**CITY OF PORTLAND, MAINE
DEVELOPMENT REVIEW APPLICATION
PLANNING DEPARTMENT PROCESSING FORM**

Single Family Home

65 - 65 George St, Portland, Maine

From: Michael Farmer
To: DiPierro, Philip
Date: 6/19/2007 2:32:40 PM
Subject: George St. residential lot

2 VERTICAL GRANITE CURB (MDOT TYPE "1")

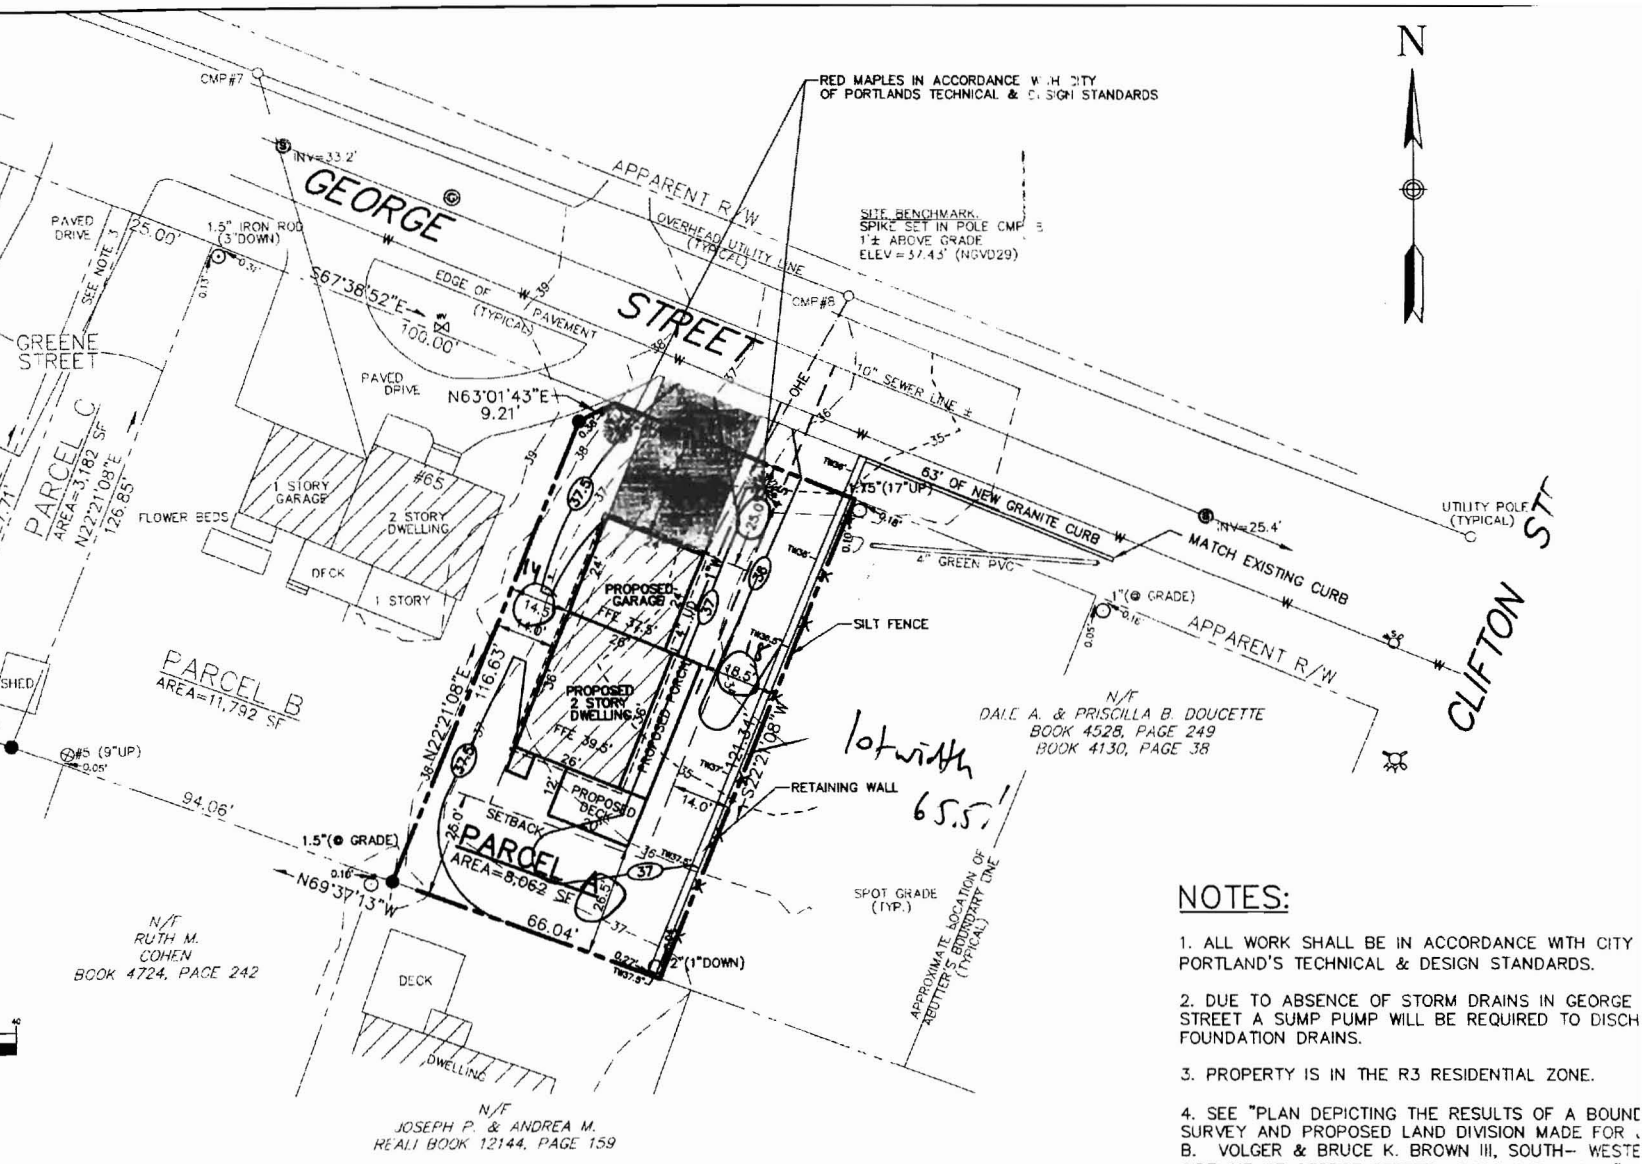
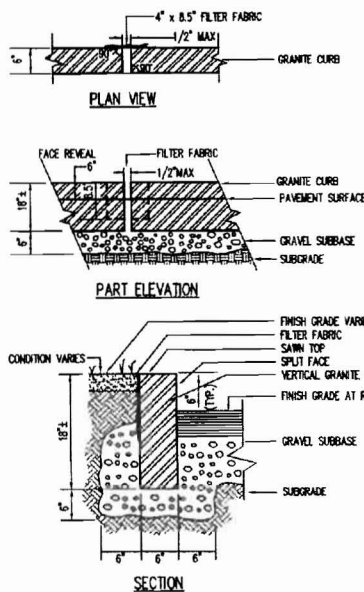
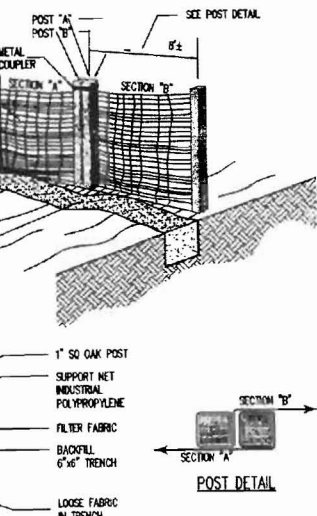
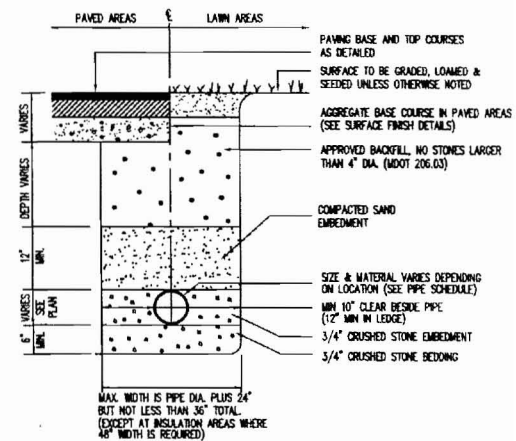
I have the following comments regarding the Stantec site plan, which was revised on 6/4/2007.

It is hard to identify a good solution to the drainage problems posed by this lot. My preference would be to eliminate the retaining wall, extend a storm drain up George Street from one of the existing catch basins at Clifton Street and install a field inlet near the front left corner of the lot, such that the inlet would benefit the lot being developed and the neighbor's lot. I think this represents the best solution for this lot; but, I have eliminated it from further consideration because it is probably too expensive for the applicant.

The proposed plan includes a concrete block retaining wall that may be offensive to the neighbor. I am not sure if we can prevent the builder from installing it on private land. But, I think we should tell the developer that the retaining wall should not be installed in the right of way. If he wants the retaining wall to be built in the right of way anyway, he needs to obtain a license from the City. A license agreement is similar to an easement. If the license is granted in this case, the homeowner would have a legal right to maintain the retaining wall in the right of way subject to the limits in the license agreement.

I am not enthusiastic about the proposal to install granite curbing in front of the neighbor's lot, but not in front of the lot being developed. If granite curbing is installed in front of the neighbor's lot, it should be extended across the lot being developed too, in which case the swale would have to be changed to direct water to the driveway. I would not object to deleting the granite curbing altogether from this project. I think filling and grading could achieve any drainage objectives that the curbing is intended to achieve.

The granite curb and pipe trench details do not agree with City standards.

Page III-3 of the Tech. standards (under Traffic) says that driveways to 1 and 2 family houses should be 20 feet apart.
